From: Judith Ward
Sent: 08 April 2020 10:54
To: Linda Griffiths
Cc: Alex Keen
Subject: RE: 20/00813/OBL BridJudith Ward <Judith.Ward@Cherwell-DC.gov.uk> leway report W of Cricket Field, Wykham Lane, Bodicote

Subject: 20/00813/OBL Bridleway report W of Cricket Field, Wykham Lane, Bodicote

Bridleway Report

Drawing Title	
S106 - BRIDLEWAY LAYOUT	
Scale	Sheet Size
1:1000	A1
Date	MAR 2020
Client Ref.	Drawing Ref.
-	2832-4-5
Drawing No.	Status
DR-5700	S4-P1

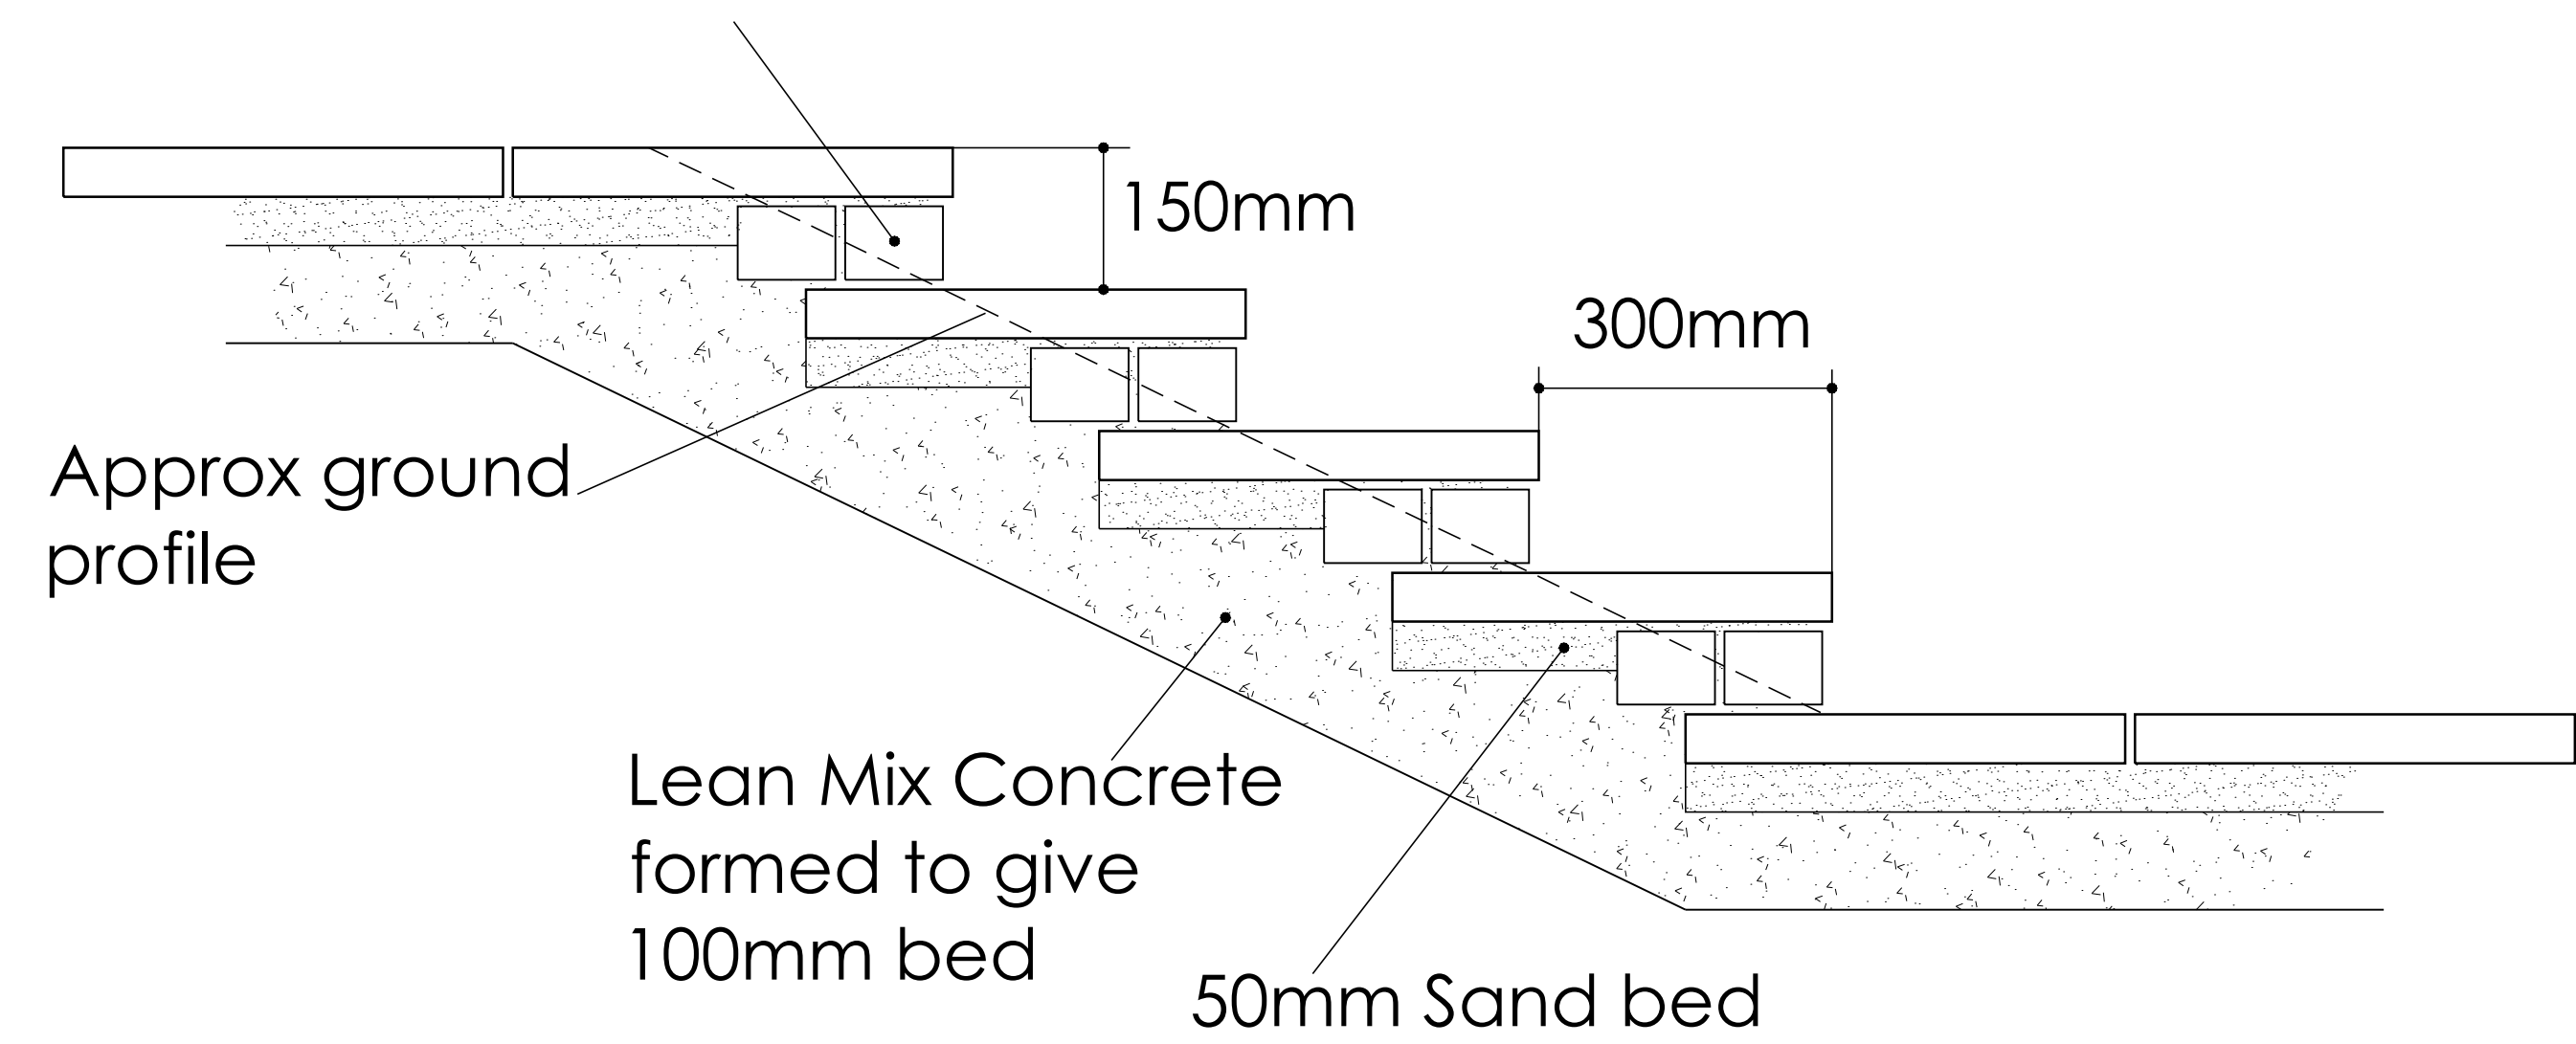
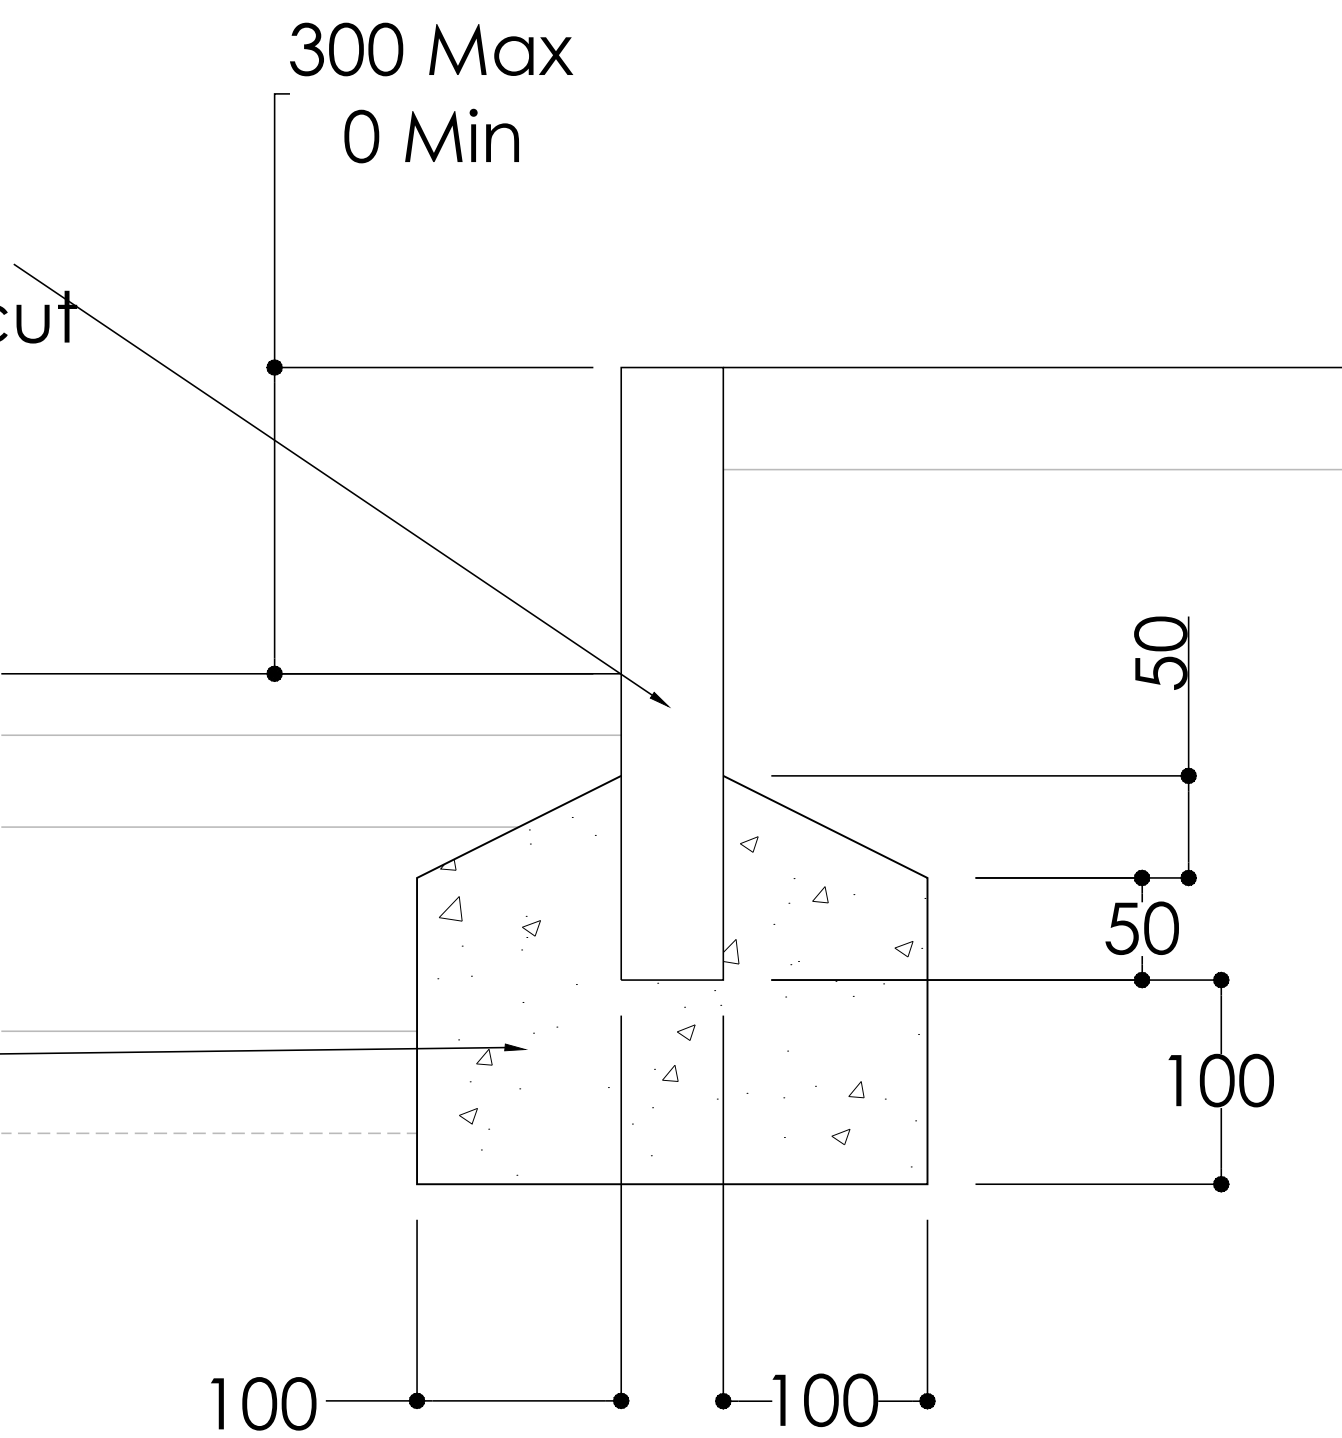
I think it would be helpful to have a plan for the bridleway with more detail than DR-5000 Landscape Masterplan.

The masterplan has items in the key that aren't on the plan and marks on the plan that aren't in the key.

There appear to be items of trim trail on the masterplan. There were on earlier planning layout BOD.PL2.001S1 and 2. However they don't appear on the landscape proposals.

It is unclear where bins, dog bins, cycle stands and seats are located. This is true of the whole area so I think we need a hard landscape plan to supplement the planting plans at a more readable scale than 1:1000.

The Hoggins needs to be specified better: 20mm to dust with sufficient fines to bind. A sample to be provided to the LPA for approval.
